Letter No. A1/5200/2005

Sub: CMDA - Planning Permission - Construction of Ground Floor + First Floor primary school building at Plot No.114 & 116 of Raju Nagar in S.No.213/1A1A & 213/2B of Okkiam Thuraipakkam village - Development charges and other charges to be remitted - Reg.

RAIN WATER HARVESTING OFFICE CO. GATE DETAILS

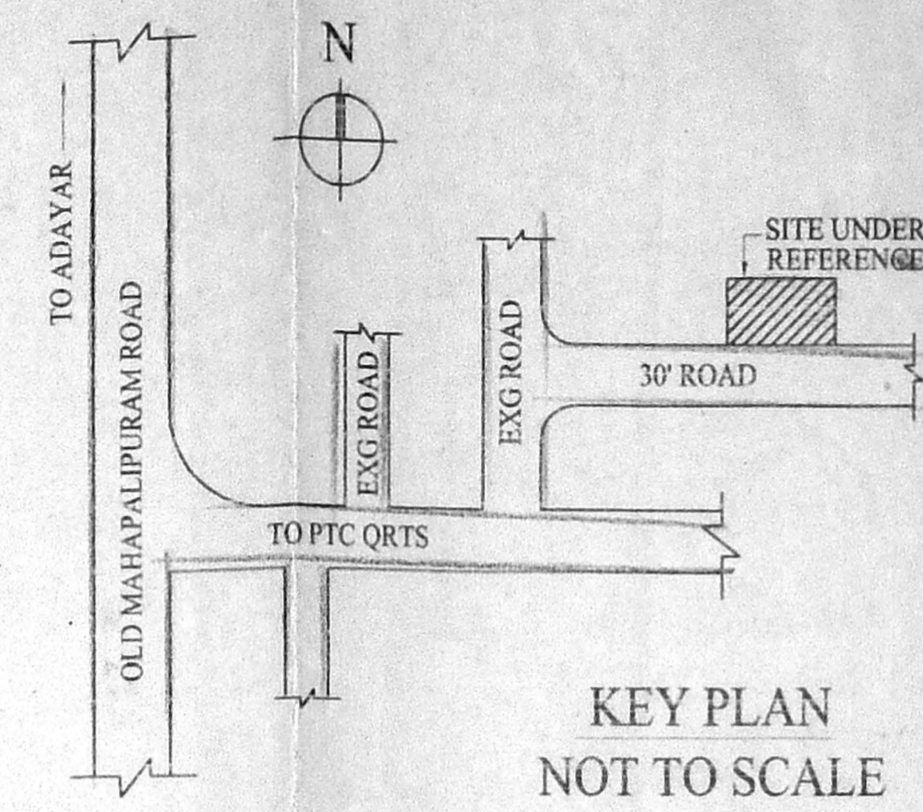
- a. Rain Water conservation Regulations stipulated by CMDA should be adhered to strictly.
- b. Five copies of revised plan showing the 3 car parking requirements.
